**KIRKLEES COUNCIL
TOWN AND COUNTRY PLANNING ACT 1990
HIGHWAYS DEVELOPMENT MANAGEMENT**

PLANNING REF 2017/62/90620/W0/MW
CATEGORY Small Major

PROPOSAL DEMOLITION OF EXISTING BUILDINGS, CHANGE OF USE OF EXISTING BUILDING TO MIXED USES COMPRISING B1A, B1C, A3, C3 AND OUTLINE PERMISSION FOR ERECTION OF 75 DWELLINGS

LOCATION DOBROYD MILLS
HEPWORTH ROAD
NEW MILL
HOLMFIRTH
HD9 1AF

Drawing 2009-2009 - Rev A
Indicative Site Sections for the
residential and mixed use
redevelopment of
Dobroyd Mills,
Hepworth / Jackson Bridge

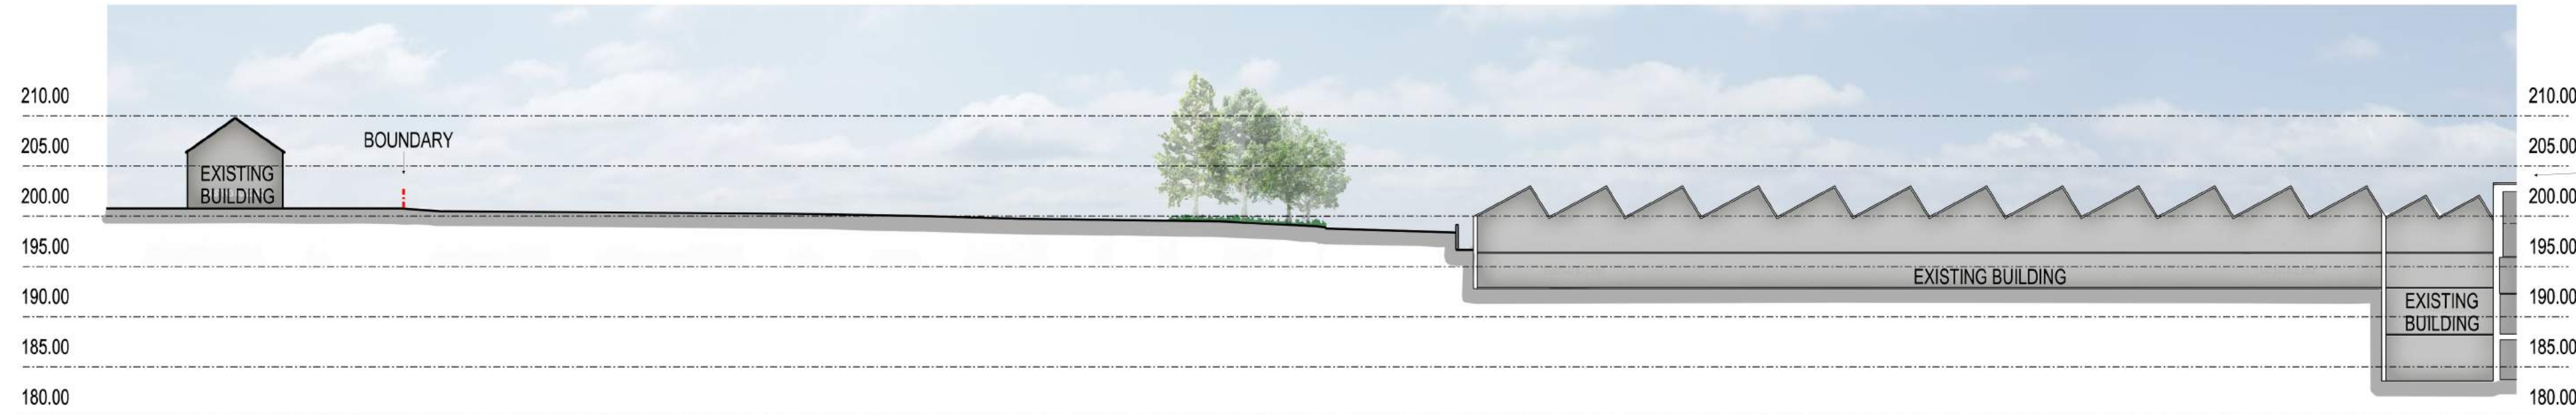
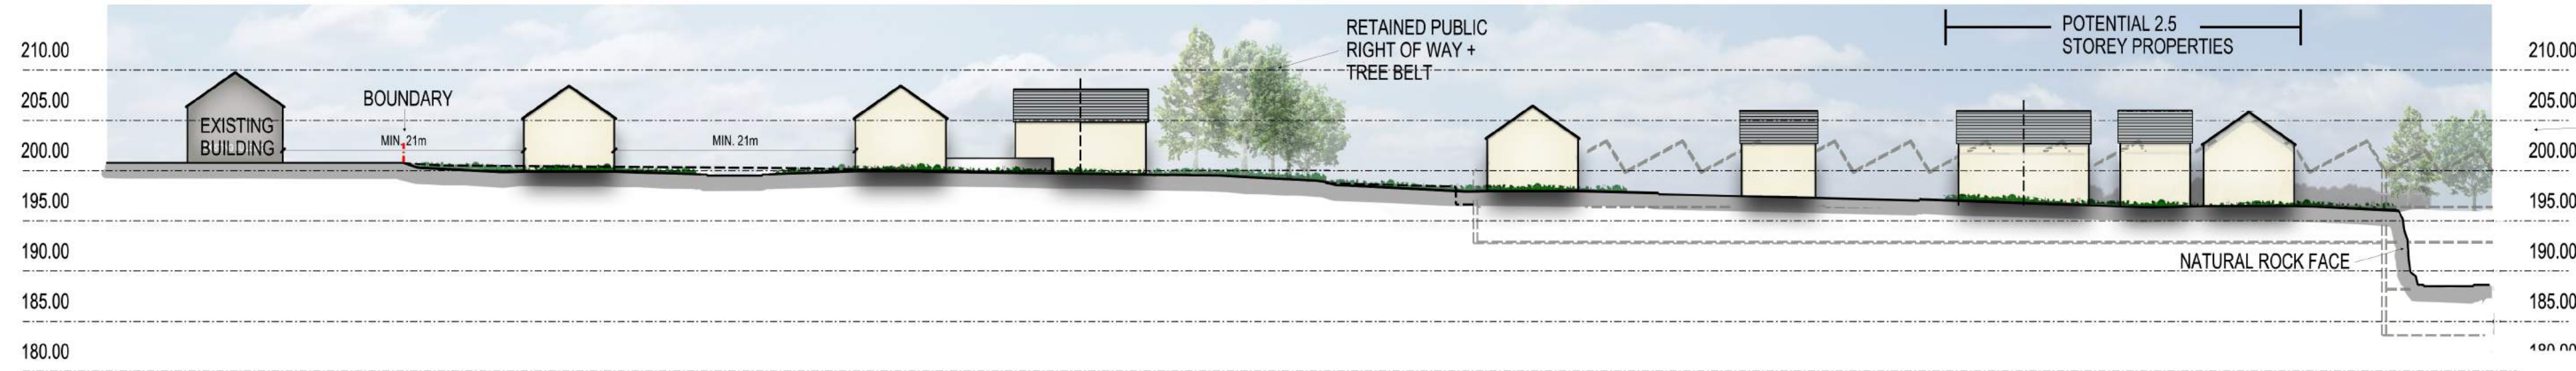
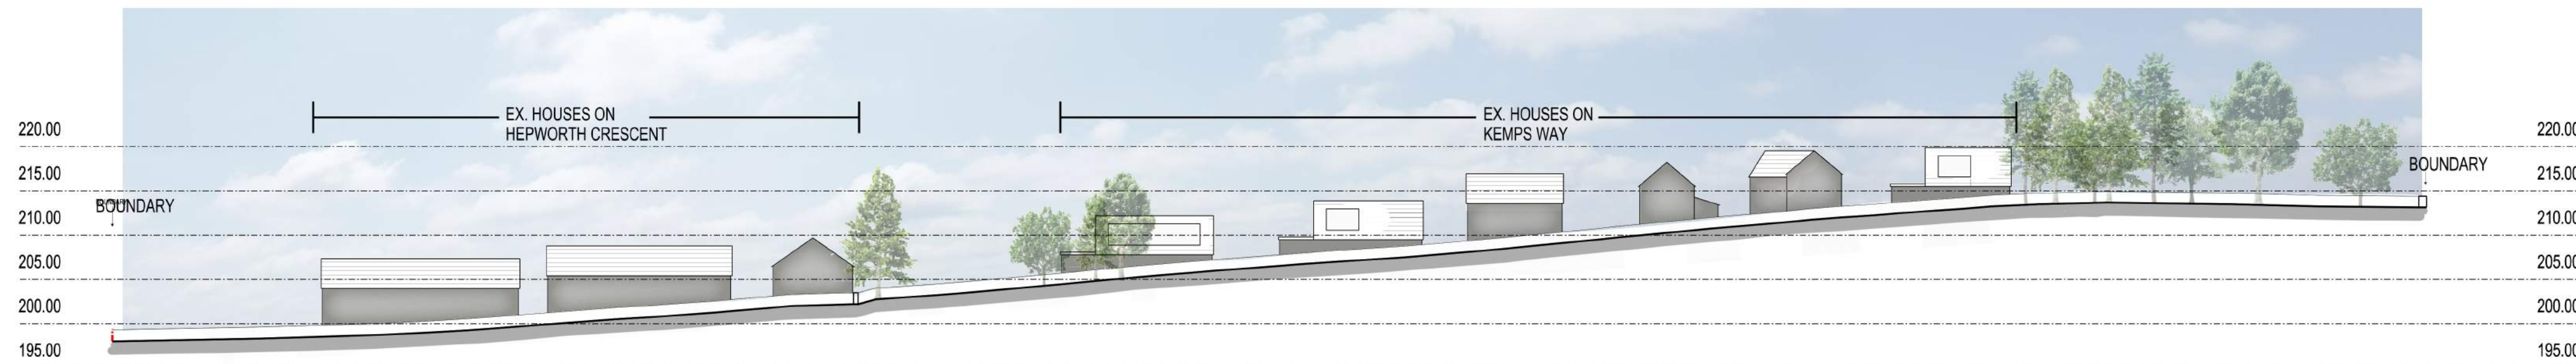
E, Longitudinal sections have been provided which show a maximum gradient of 1 of 14. This section should be drawn with a 1 to 10 exaggeration and 20 metre vertical curves should be shown between changes in direction.

KIRKLEES REFUSE VEHICLE	
OVERALL LENGTH	11.850m
OVERALL WIDTH	2.500m
OVERALL BODY HEIGHT	3.749m
MIN BODY GROUND CLEARANCE	0.302m
TRACK WIDTH	2.490m
LOCK TO LOCK TIME	6.00s
WALL TO WALL TURNING RADIUS	11.000m

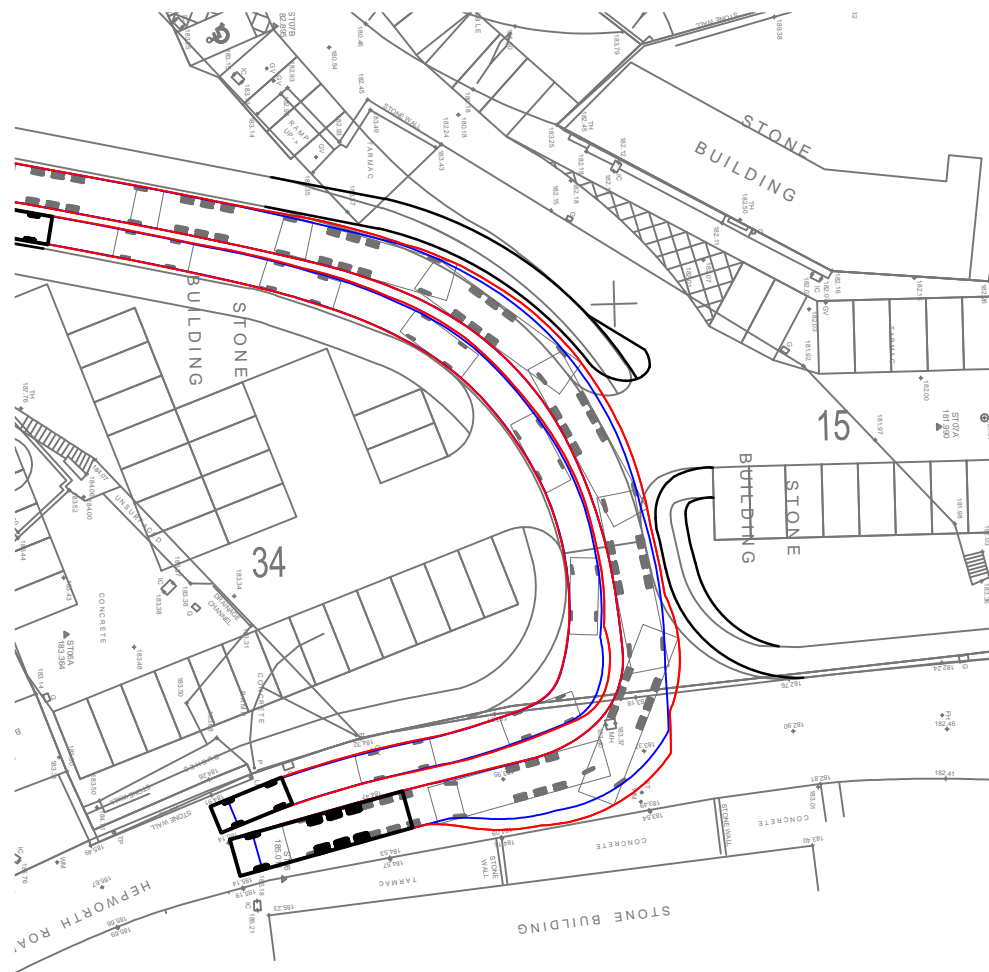
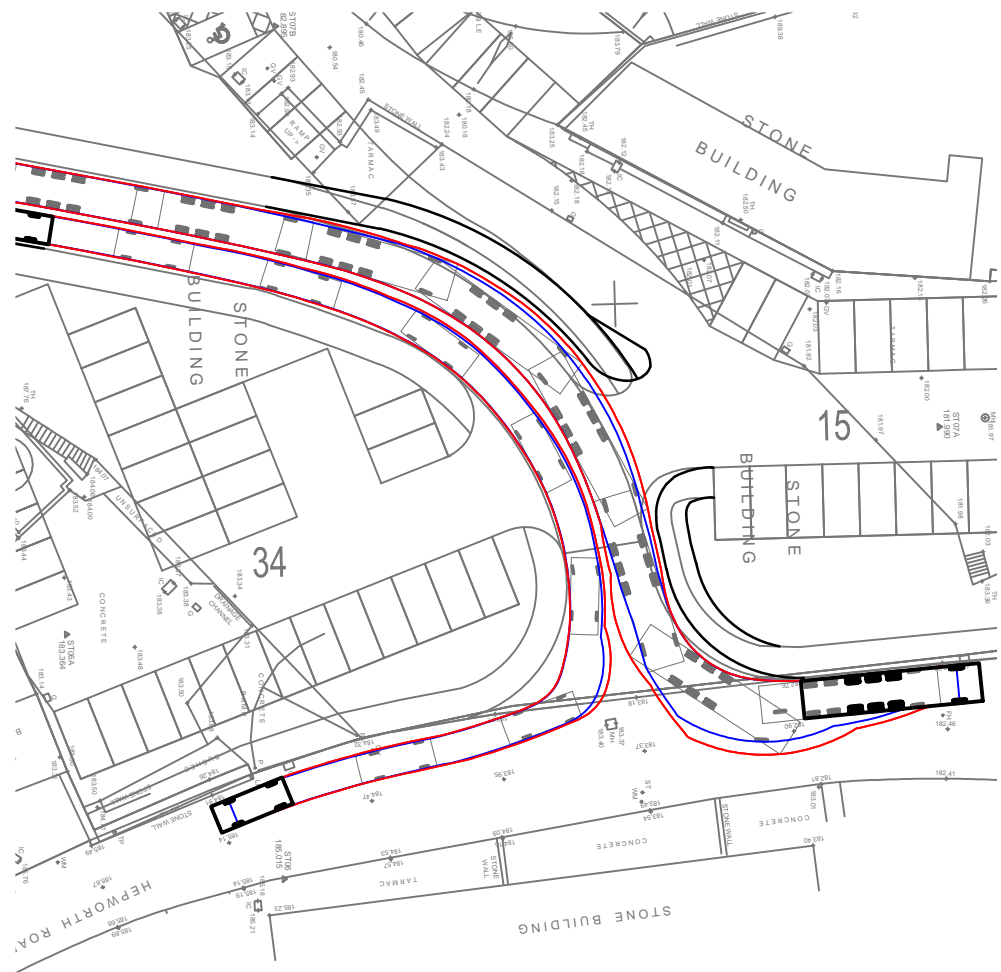
G, The swept paths provided do not show the left turn in or right turn out onto Hepworth Road. Given

the various uses the access should be wide enough to allow a refuse vehicle to pass another vehicle at the access and along the access road given the horizontal alignment through the site. A refuse vehicle would have to use the full road width as currently proposed. The turning movement shown to the turning head is tight and this needs to be improved in width to allow more comfortable turning and manoeuvre.
